Transportation

Case: 13226/APP/2012/2185

Address: Forma Powergen Site, North Hyde Gardens, Hayes

Proposal: Redevelopment of the site to provide an aggregate recycling and processing plant, asphalt plant and storage facility, gully waste recycling plant, aggregate storage facility, and term maintenance depot, with ancillary offices, structures and facilities, car and lorry parking, regrading, and landscaping

Figure 3.1: Proposed Development Layout

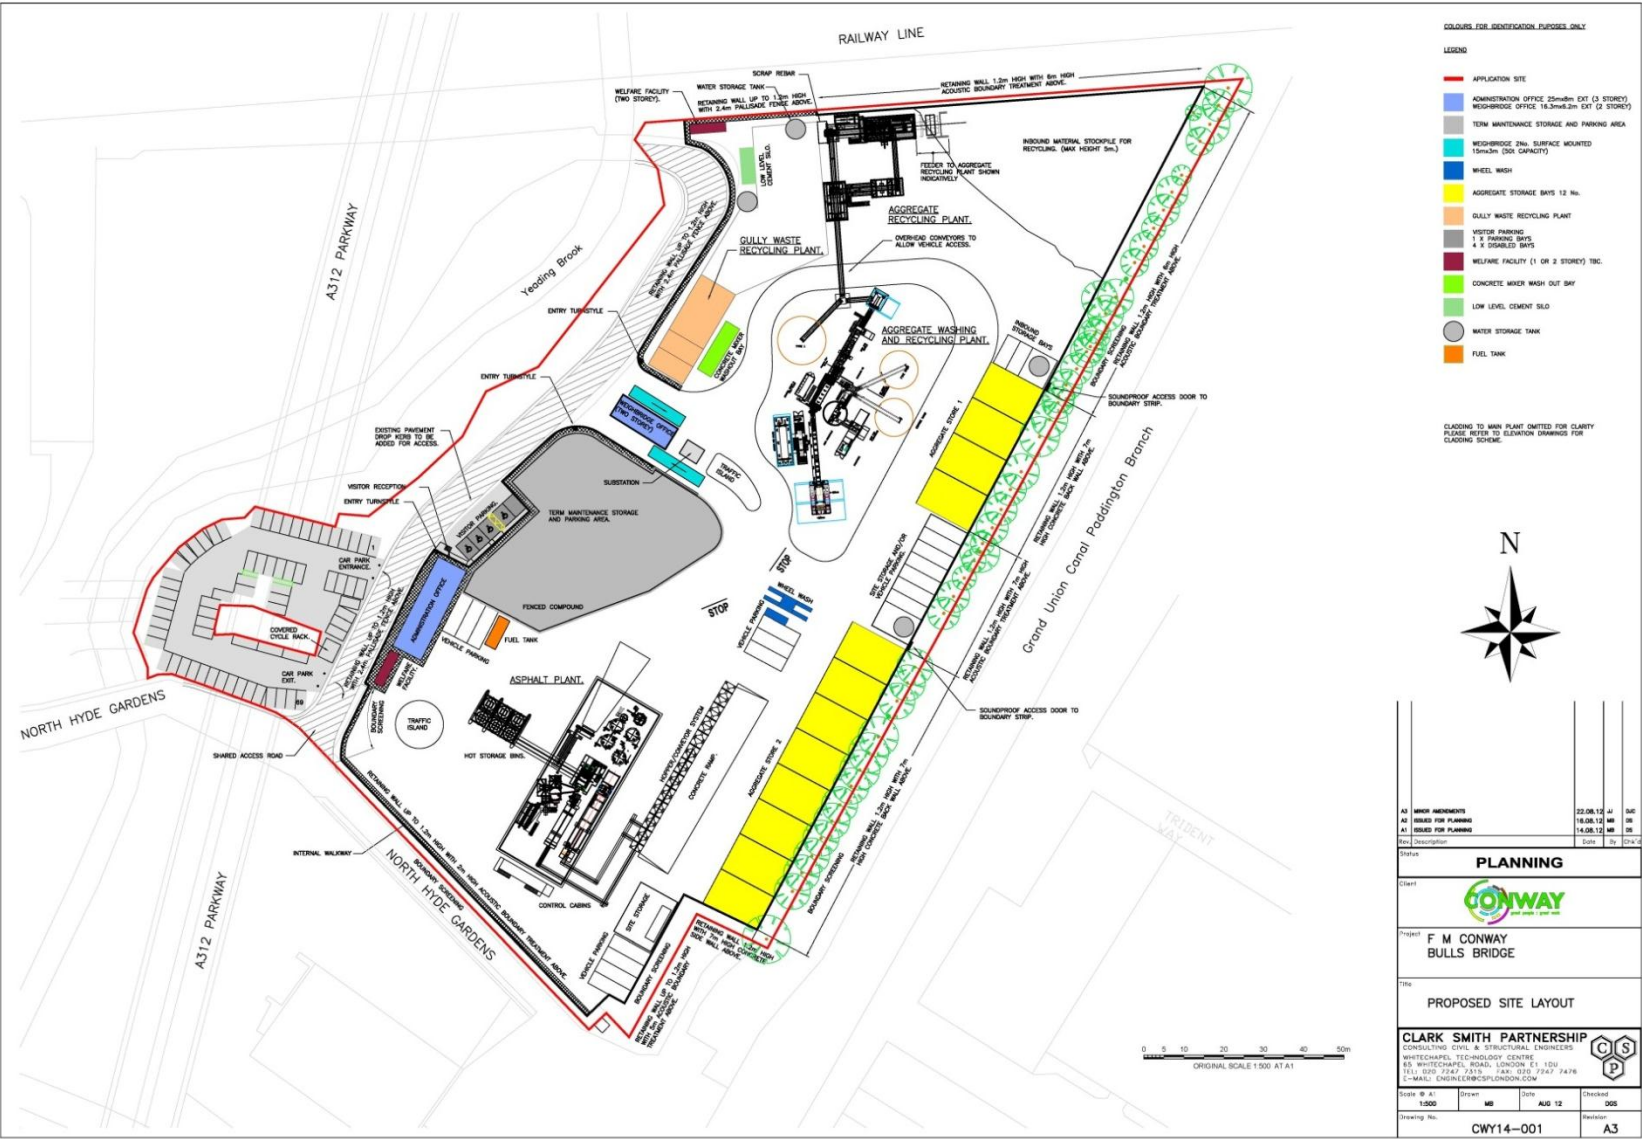
It is noted that a total of 76 non-operational car parking spaces will be provided as part of the development proposals, with 70 parking spaces allocated for the use of staff and 6 parking spaces allocated for customers. Based on 79 members of staff being employed at the site, this equates to a ratio of around 0.9 parking spaces per employee.

While it is noted that accessibility to public transport is low, it is considered that this level of parking is excessive based on current policies and the travel plan initiatives that will be provided as part of the development proposals. Therefore, the proposed level of staff parking is required to be reduced, considering the aims and objectives of the submitted travel plan.

It is noted that the Transport Assessment does not consider the provision of cycle parking within the boundary of the site for the use of staff. However, the Travel Plan submitted in support of the development, identifies measures that will be implemented to promote cycling, which include the provision of cycle parking when the demand has been assessed. Notwithstanding the proposed future assessment of demand, it is considered that a total of 8 cycle parking spaces (4 cycle stands) are required to be provided within the site.
